Our Ref: AW/79/20/HH

**Town & Country Planning Act 1990 (as amended)
Town & Country Planning (Development Management Procedure) (England) Order 2015
Application for Householder Planning Permission**

Development Side extension to enlarge kitchen and dining room
Location 175 Nyetimber Lane Aldwick

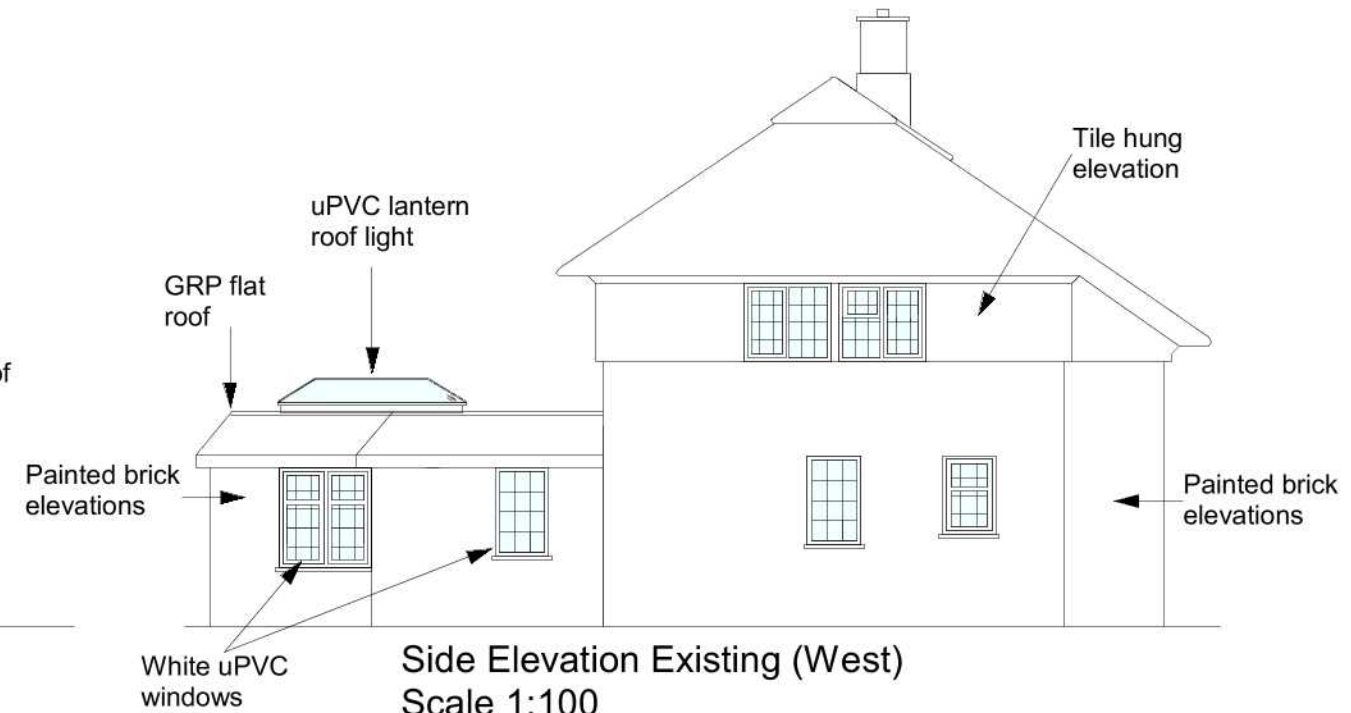
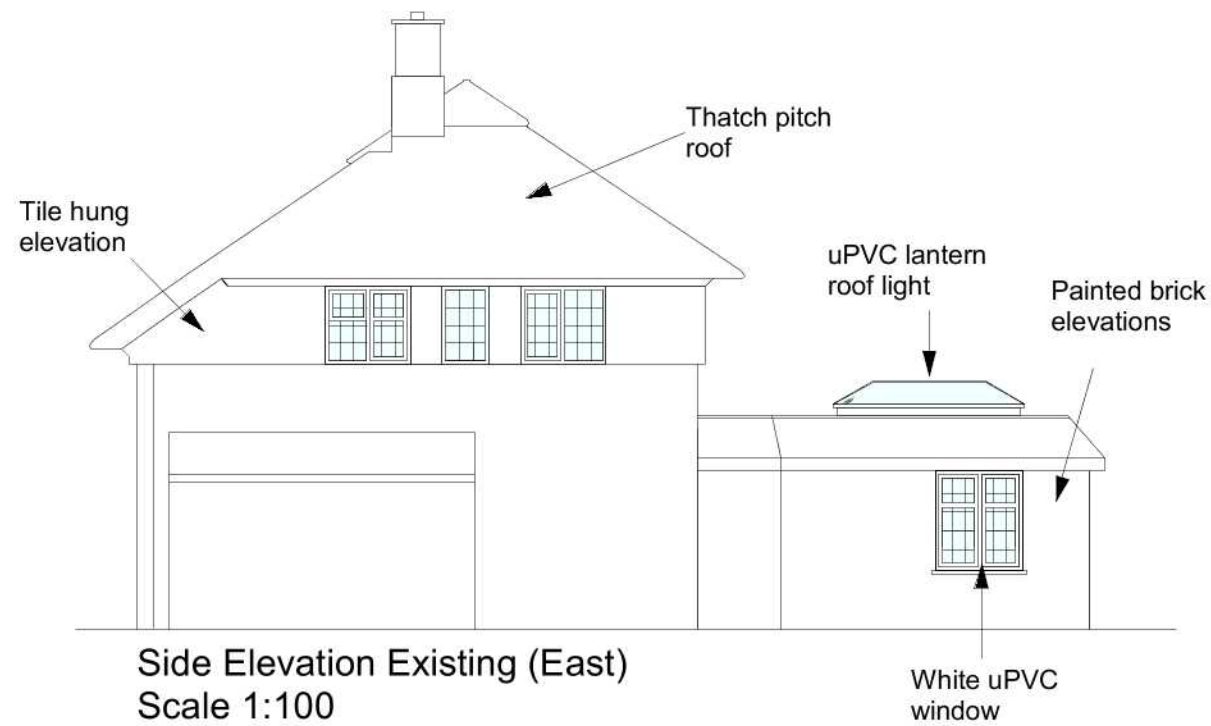
Elevations

One of the existing elevations is labelled proposed. Please amend. Apologies this was not mentioned previously.
